**89 JOHN WHITEWAY DRIVE, GOSFORD (SSD-10321)
REQUEST FOR ADDITIONAL INFORMATION**

We refer to your letter requesting additional information dated 1 July 2021 in which the Department of Planning, Industry and Environment (the Department) has requested some additional information to inform the Department's assessment of the State Significant Development Application (SSD).

Project Number	Drawing Number	Rev
19002	DA002.1	16
Coordinator : Approver	Checked : Checker	
Scale: As indicated @ A1	Date Printed: 2021-07-26 3:16:28 PM	
File Name:

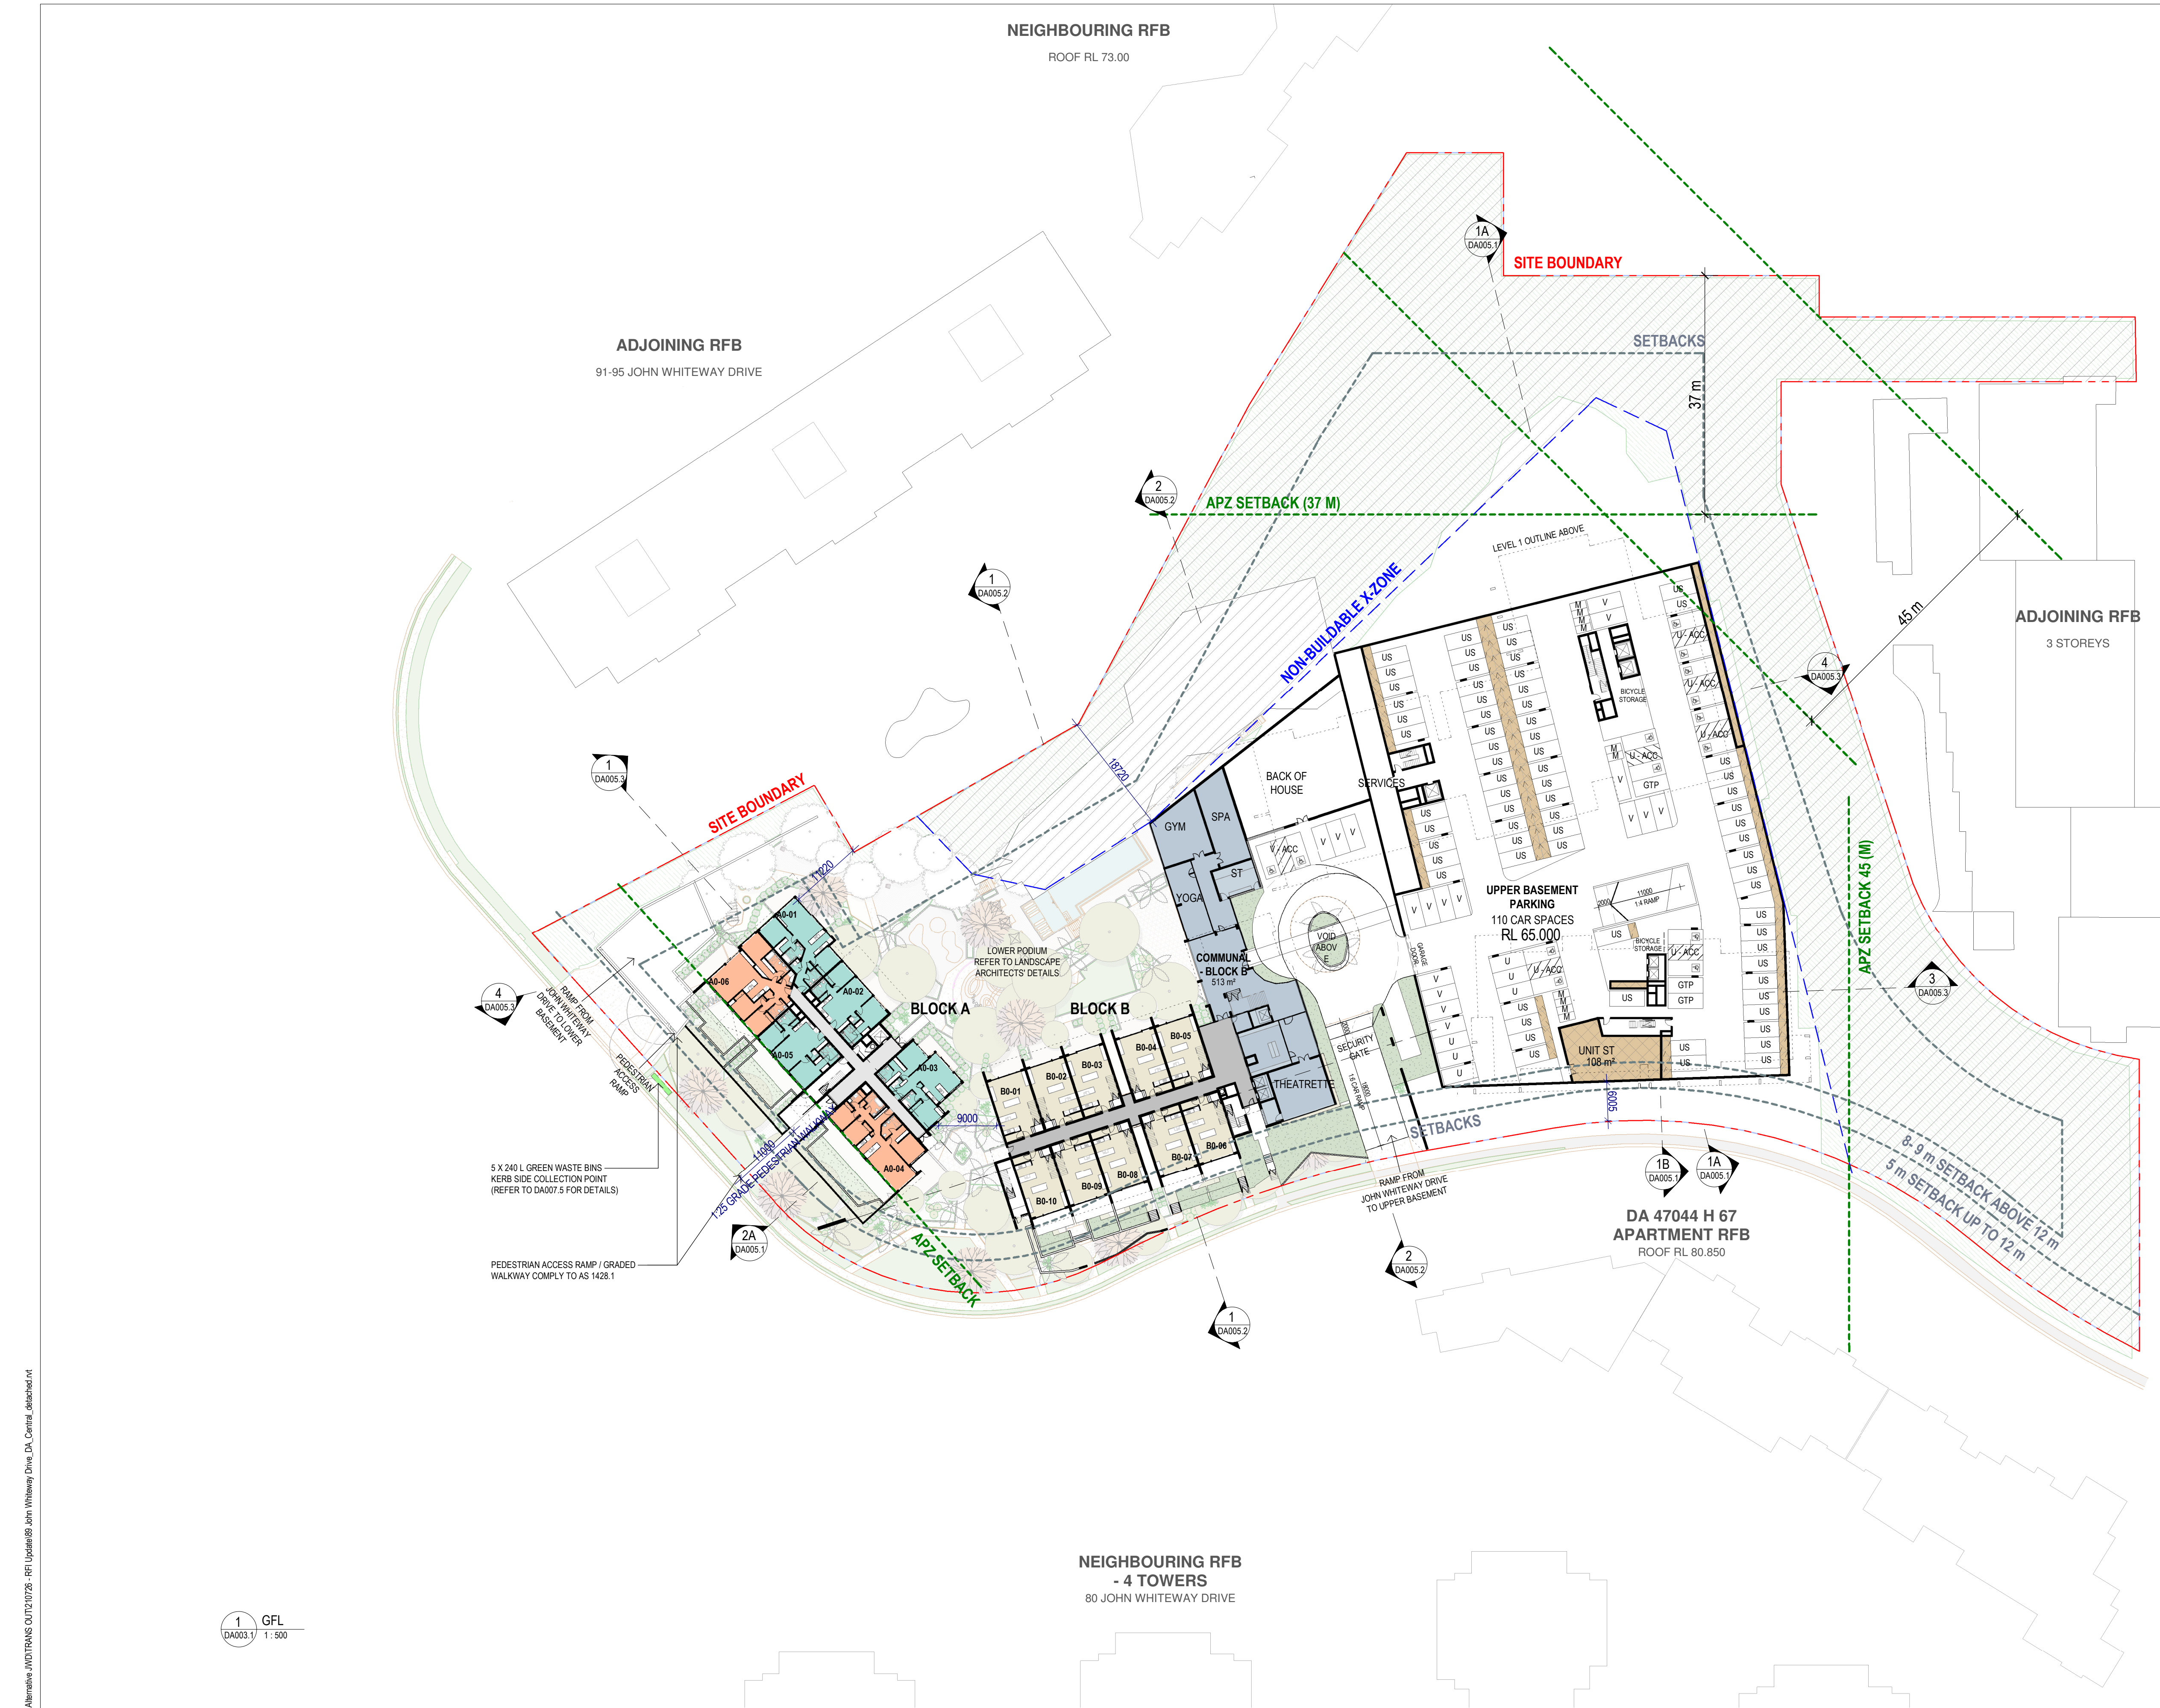
<p>Basement Entry</p> <p>Please indicate the location of the security door to the basement entry on the architectural plans.</p>	<p>See Section 1.4 below and Appendix E.</p>
<p>Tree Canopy Survey</p> <p>As requested previously, please provide a copy of the tree canopy survey to inform the Departments assessment. It is noted that a copy of the survey was provided by Ethos with the RtS, however due to the file type it could not be opened. Please provide the survey in a PDF format.</p>	<p>The tree canopy survey is cloud based information and not capable of being printed in 2 dimension or PDF format. The survey was a request of the Department to inform the built form massing, and the Planning Principles for the site.</p>
<p>BASIX</p> <p>The BASIX certificate provided with the amended DA states ‘this is not a valid certificate’. Please provide a valid certificate to support the amended DA or any future amended plans.</p>	<p>See Appendix F.</p>

Architectural Plans DA002.1 and DA002.2 (**Appendix E**) have been amended to better identify garage doors, as shown at **Figure 3** and **Figure 4** below.

Project Number	Drawing Number	Rev
19002	DA005.9	12
Coordinator : Approver	Checked : Checker	
Scale: As indicated @ A1	Date Printed: 2021-07-26 4:40:33 PM	
File Name:

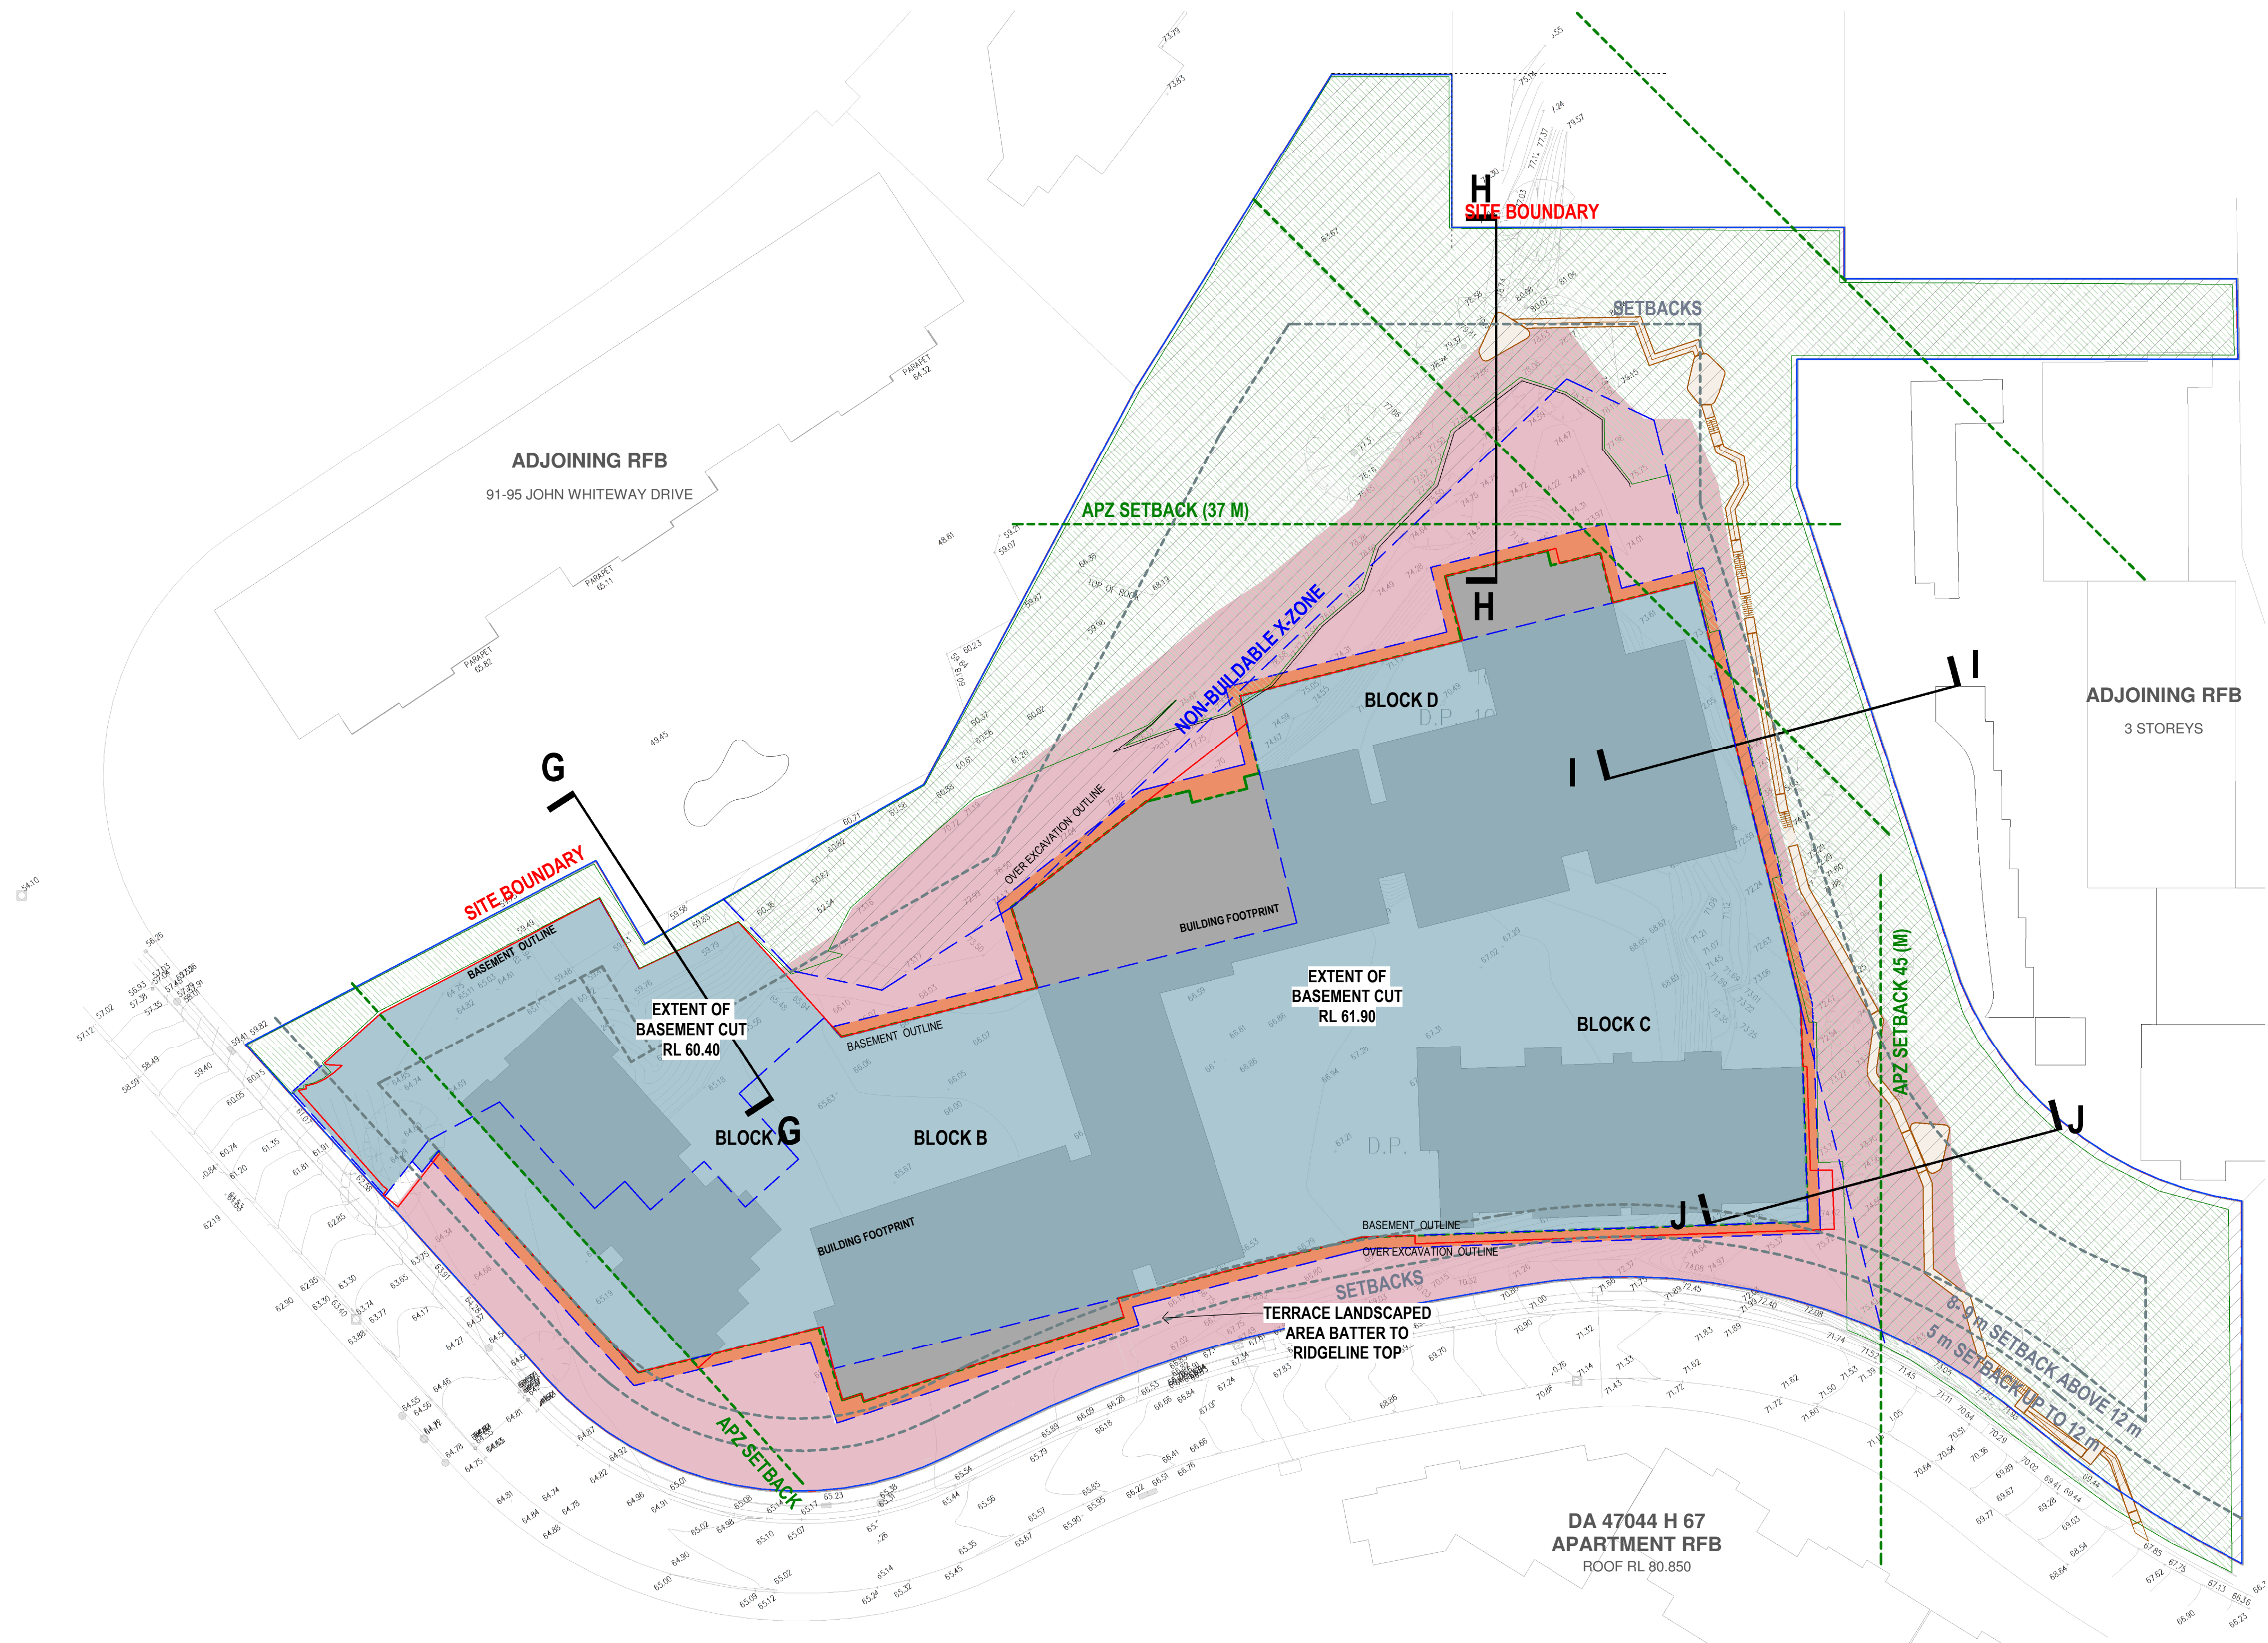
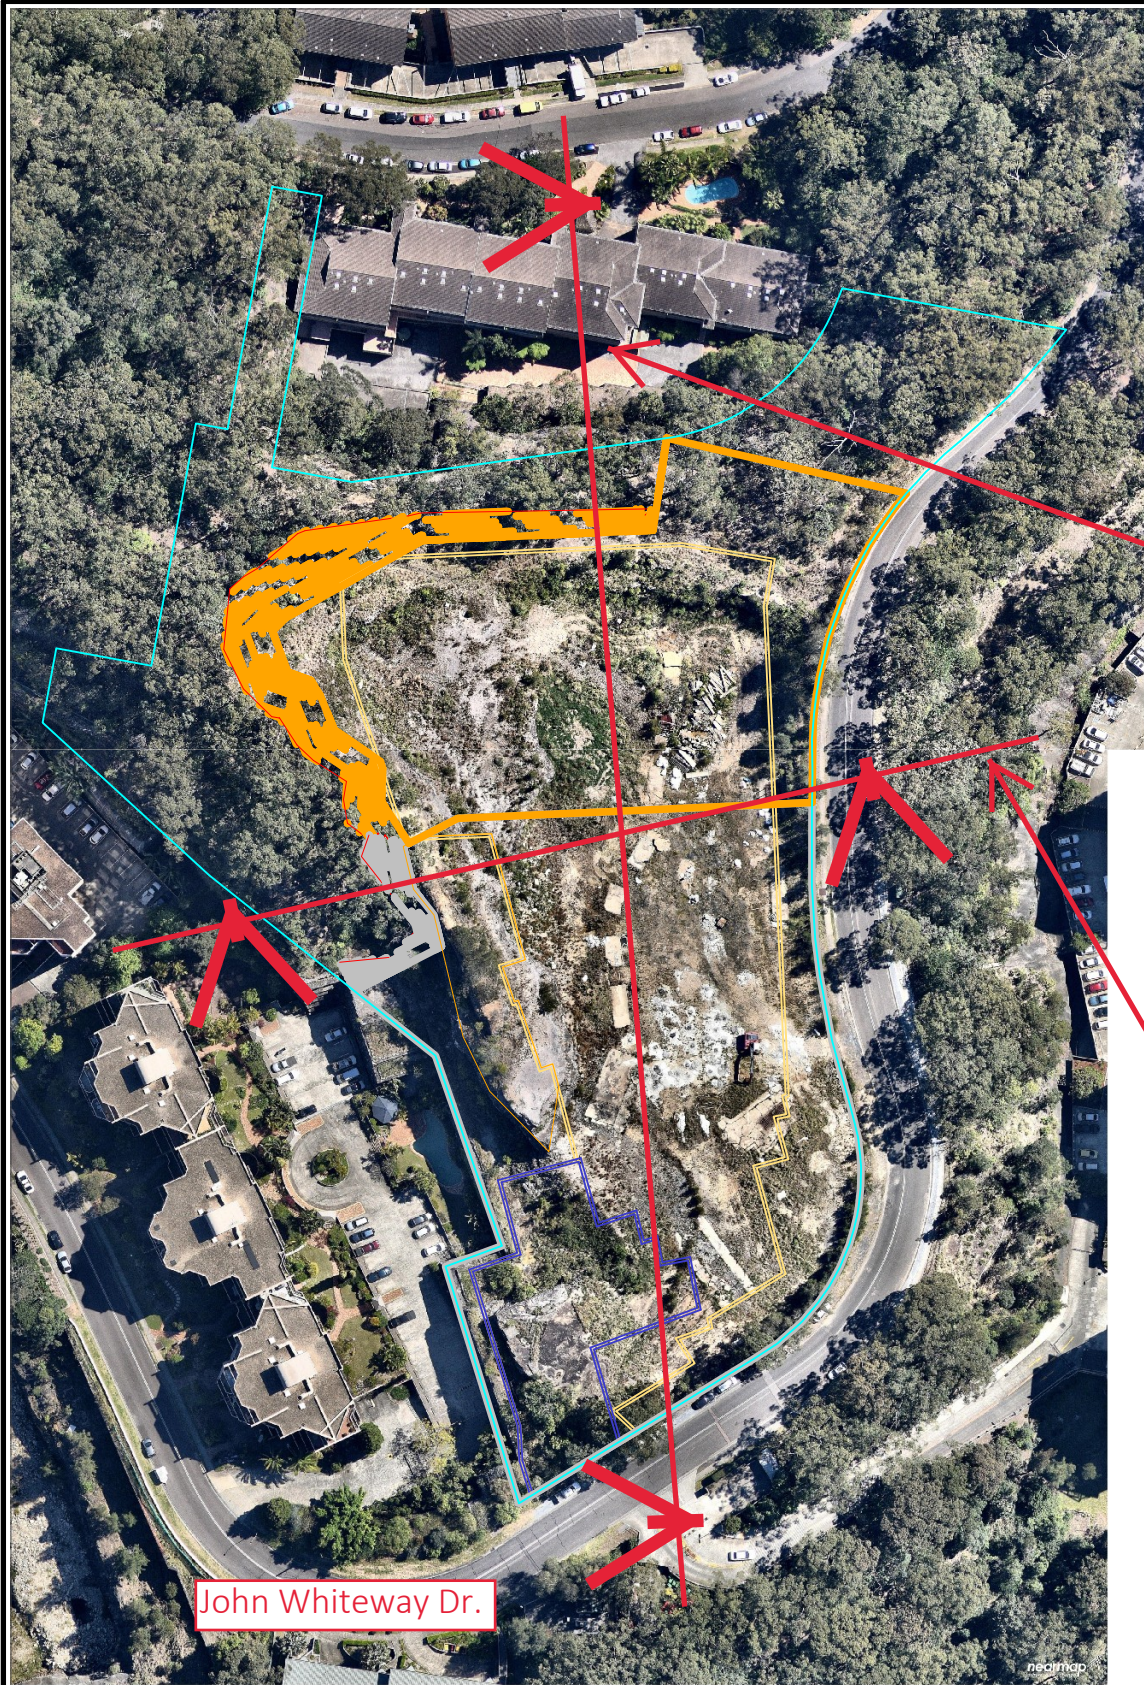
Comment	Response
<p>the communal open space that is designed as the primary focus of recreational activity and social interaction’.</p> <p>The Department requests that the shadow analysis be updated to identify the principal areas of communal open space and demonstrate solar access compliance in accordance with the ADG. Please note that inaccessible vegetated areas, the front setback and the public walkway are not considered to be principal communal open space, in accordance with the definition.</p>	<p>achieves greater than the 2 hours required under Objective 3D-1 of the ADG, being 3 hours solar access in mid-winter.</p>
<p>Excavation</p> <p>The Department requests further clarification on areas of excavation across the site. Further details of cut and fill across the site is required, clearly identifying areas of excavation, existing and finished ground levels, as well as RL’s beyond the excavated area. This detail must be shown on a cut and fill plan, as well as section plans, showing the extent of excavation across the site, including (but not limited to) to the following areas:</p> <ul style="list-style-type: none"> • Northern and western boundaries and the eastern boundary adjoining units C1-05 to C1-08. • The north facing level 1 units within Blocks C and D, so the interface of these units with the northern cut and batter can be adequately considered. • The proposed landscaping area adjoining the western side of the communal swimming pool (Drawing No. 10-19.32), which encroaches beyond the non-buildable area. • Any other areas of excavation that fall outside of the buildable zone. 	<p>A consolidated cut and fill information drawing set is provided at Appendix D.</p>
